# BEACON FEN ENERGY PARK

Planning Inspectorate Reference: EN010151

Applicant's Responses to Other Parties Deadline 6 Submissions

Document Reference: 9.24

Appendix 1a – Soil Stockpiles Indicative Cross Sections

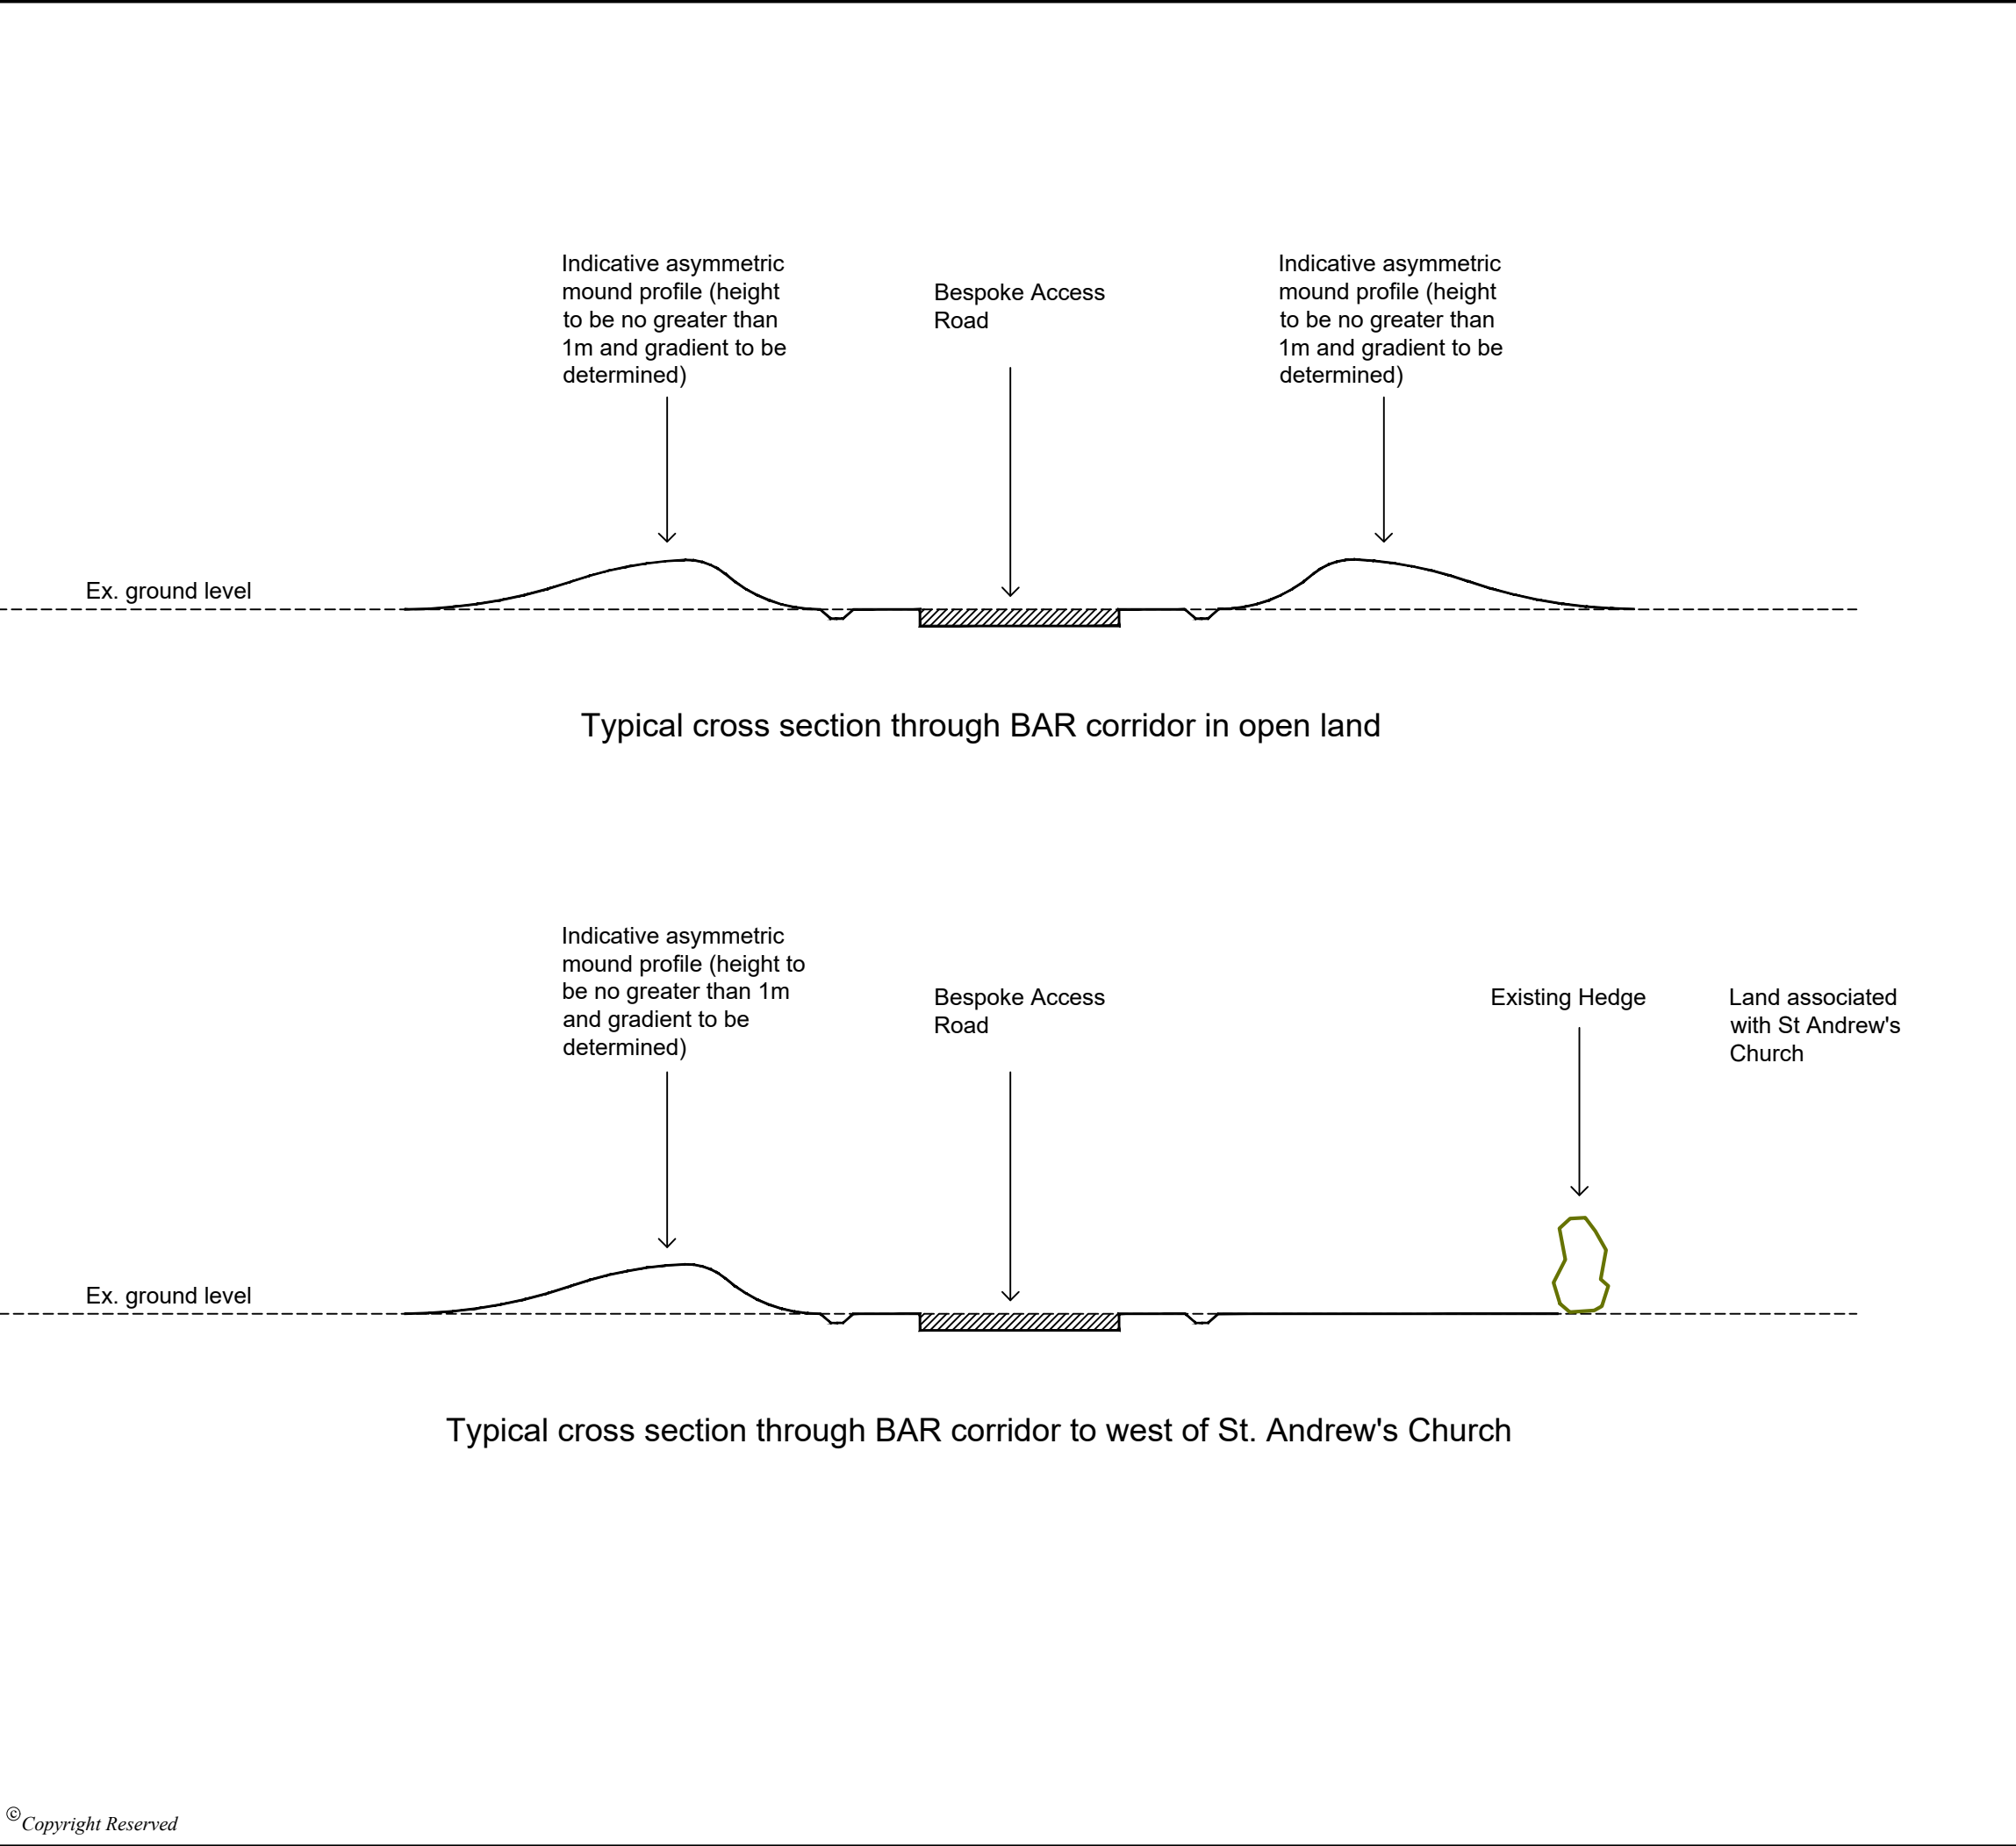
Paragraph 6.3.20 of the updated LVIA identifies Stockpiles at 0.5 to 1.0m in height adjacent to the bespoke access road. There are two concerns in regards to these features:

1. The bunding would be out of character in this landscape and would likely appear as an engineered feature. This is a relatively flat, open landscape, and bunding such as that proposed would potentially be conspicuous in views and out of character with the existing landscape. We do however acknowledge that these are currently proposed as relatively low features, lessening their presence in views. Paragraph 6.6.57 of the LVIA has been updated to consider

these new features, however we disagree that these elements will harmonise with the immediate context of the agricultural landscape as they will likely appear as engineered elements out of character with the existing landscape character and in themselves have the potential to have adverse landscape and visual effects; and

2. A topsoil stockpile for use decades later is not likely to be effective. We would welcome clarification from the applicant in this regard and a maintenance process that would maintain the topsoil integrity, but topsoil stockpiles are typically in place for a relatively short amount of time, usually 6 to 36 months. The characteristics of the soil are likely to change over a protracted period of time when in a stockpile, and in our experience unlikely to be useable.

The Applicant notes the concerns of LCC with regard to the soil stockpiles, but notes the following:

- The soil stockpiles are a necessary element of the Bespoke Access Road. They are required for the long term storage of topsoil, which will be used to reinstate agricultural land following decommissioning;
- They are relatively low, up to a maximum of 1m above existing levels; and  
The profile of the stockpiles has been designed specifically to avoid the appearance of 'engineered bunds'. The design approach is to create a 'false cutting' with a relatively shallow

outer slope which will provide a gradual transition with the existing landform. The stockpiles will be sown with a neutral grass seed mix which when established will provide an appropriate association with the agricultural landscape context as set out in paragraph 1.5.9 of **Appendix 6.7 Outline Landscape and Ecological Management Plan (Revision 4) (Clean) (REP6-022)**. The proposed location of the stockpiles is illustrated in the **Landscape Strategy Plan Part 2 (CR-020)** and the profile is shown in **Applicant Responses to ExQ2 (REP5-048)** in Appendix 2: Soil Stockpiles Indicative Cross Section.

The proposed maximum topsoil stockpile height of 1m will help ensure that soil quality is retained over the duration of the storage period and the soils are viable for reinstatement at the point of decommissioning. Industry guidance states that topsoil stockpiles should not exceed 3m to ensure that soils do not lose structure. The base of the proposed 1m stockpiles will therefore be even less susceptible to compaction and will ensure good structure is retained. The stockpiles will be seeded with a neutral grassland mix and actively managed throughout the operational period as set out in paragraphs 1.5.8 to 1.5.17 of **Appendix 6.7 Outline Landscape and Ecological Management Plan (Revision 4) (Tracked) (REP6-022)**. An actively managed vegetation on the surface will protect the soils from surface erosion. The seed mixture will include a wide range of plant species with a variation in rooting depths. This will help ensure the soils remain active throughout the profile depth.
